**Thanet Extension Offshore Wind Farm**

Annex A to Appendix 34 to Deadline 3 Submission: Log of Changes to the Draft  
Development Consent Order

Date: March 2019

Revision C

Onshore Street Work Plans - Sheet 1 of 2

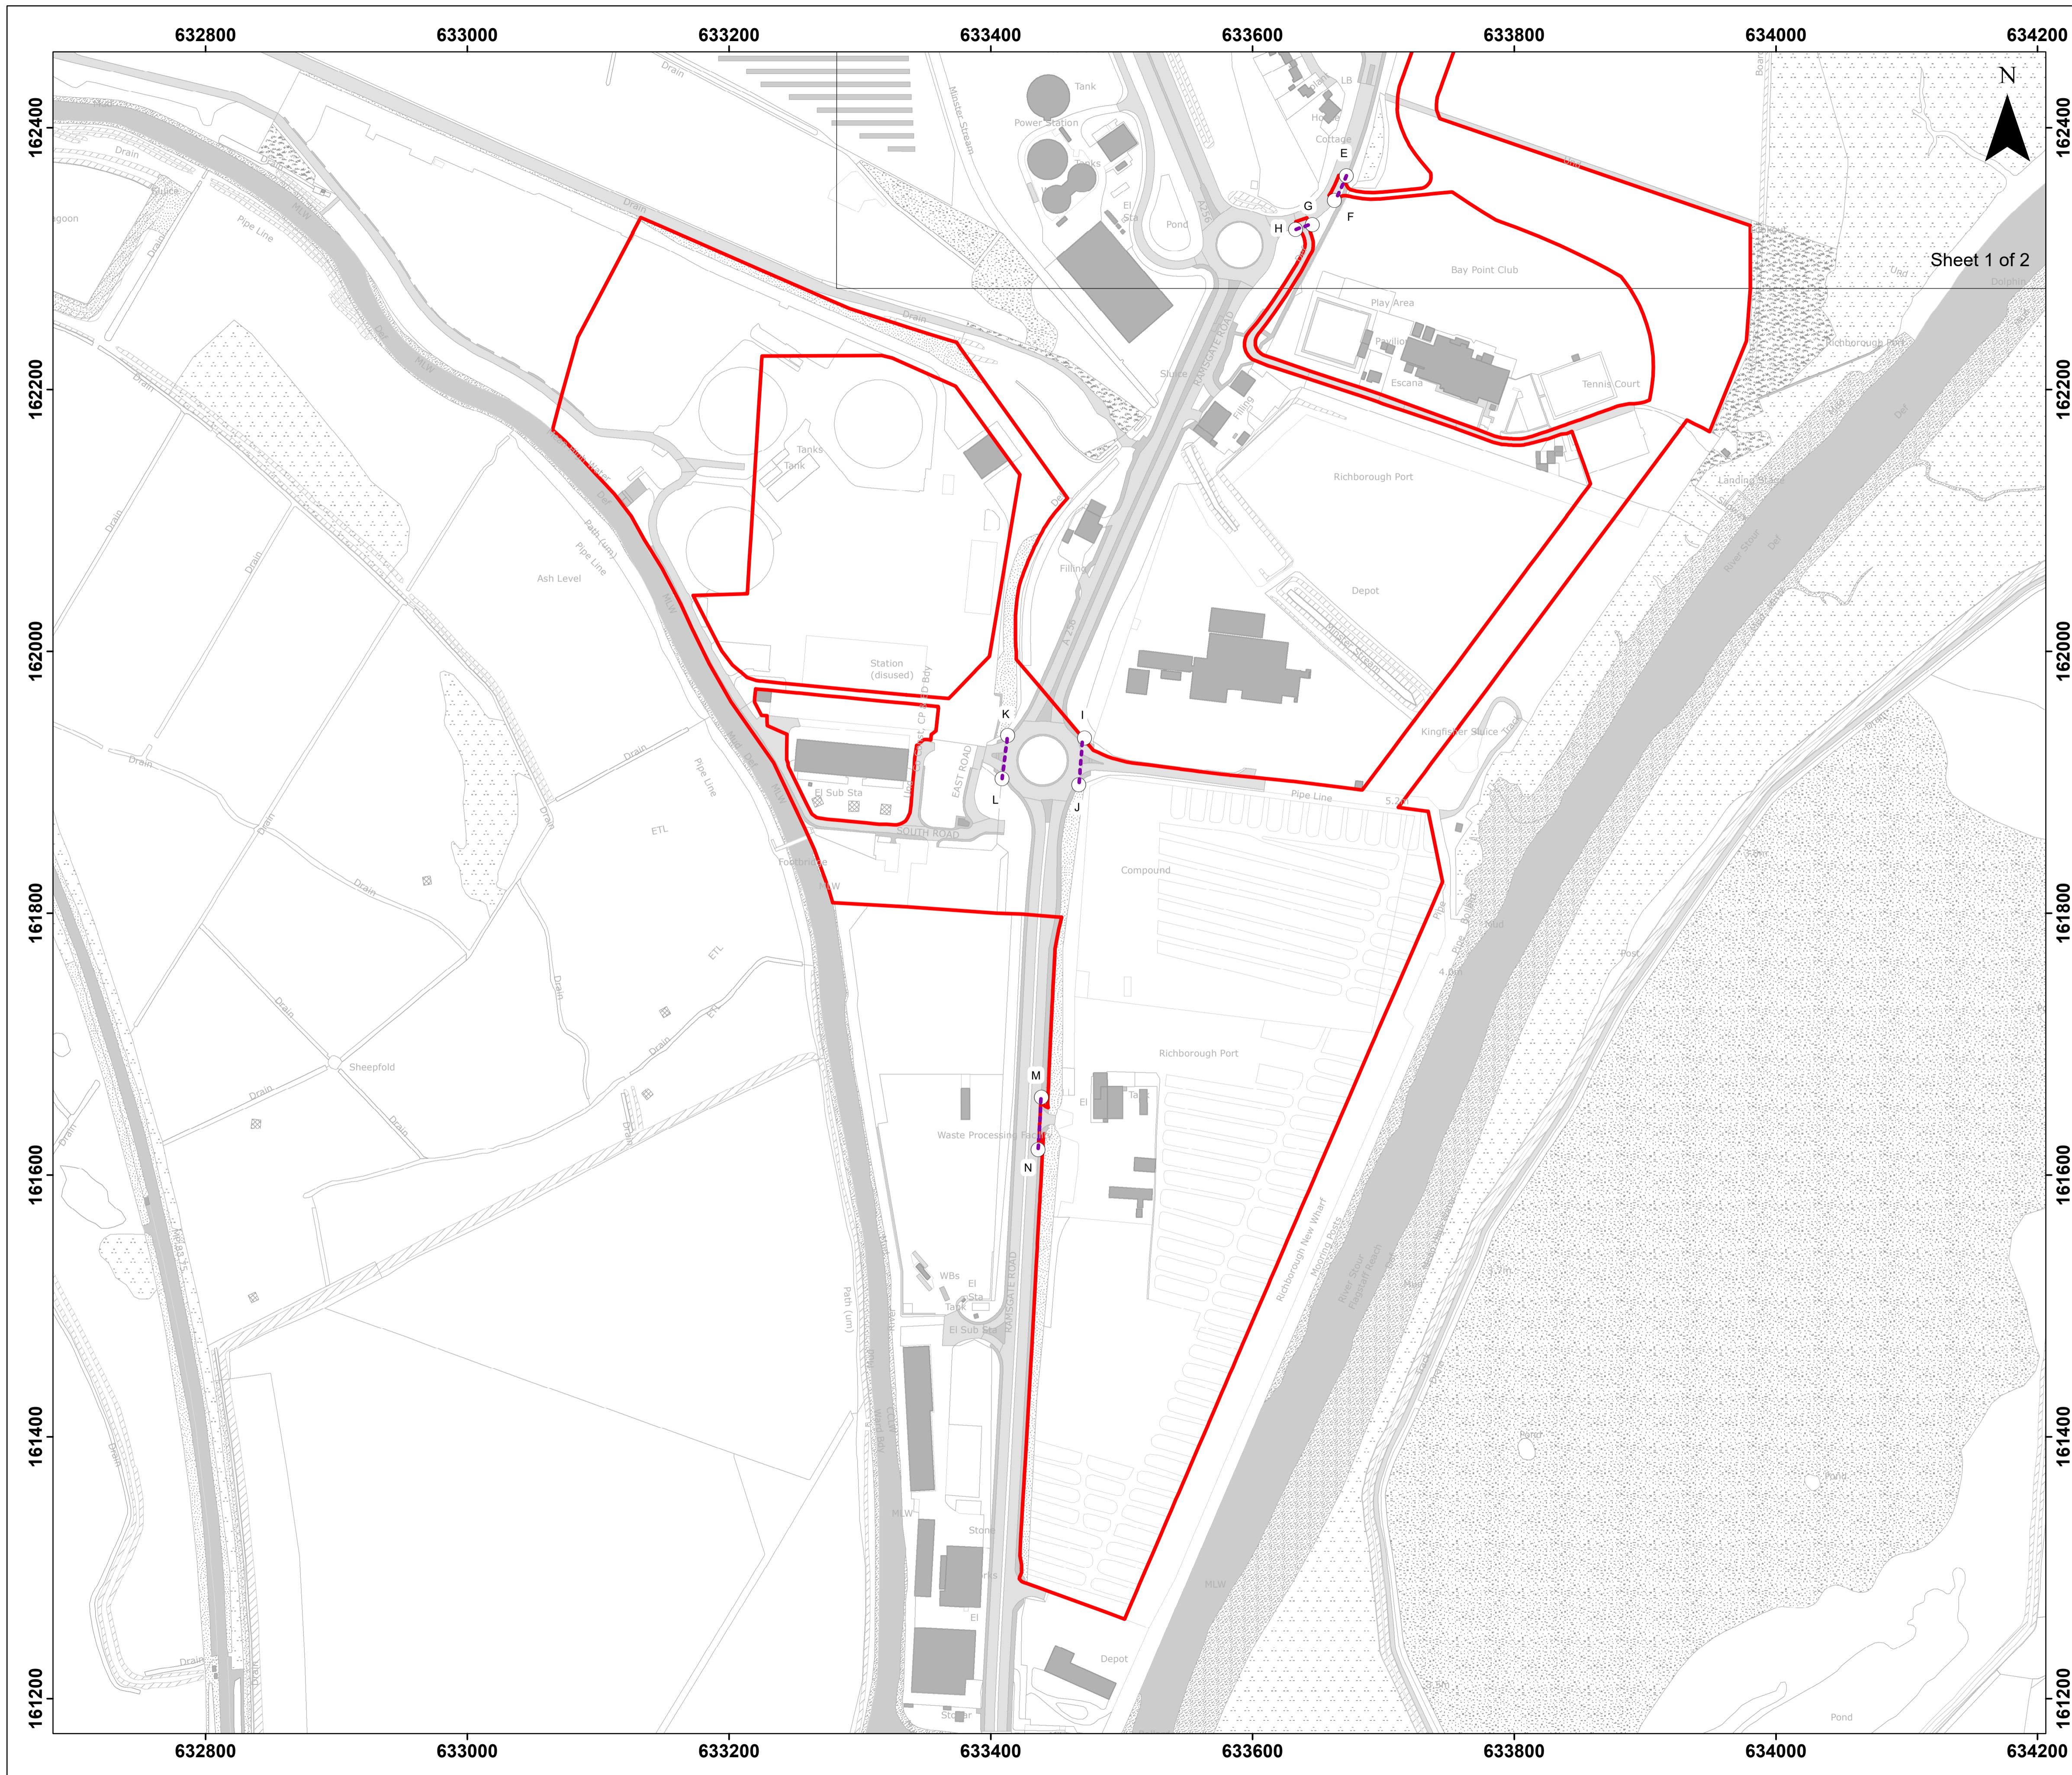
Ref	DCO Ref.	Rationale for change	Change made	DCO Version
1.	Schedule 2	In their Section 51 advice issued to the Applicant, the Planning Inspectorate noted that:  “In relation to the dDCO Schedule 2, the dDCO refers to the works plans. This should be the onshore street works plans.”	The wording has been amended throughout Schedule 2, for example –  <i>SANDWICH ROAD at reference point A-B on the <u>onshore street</u> works plan</i>	2
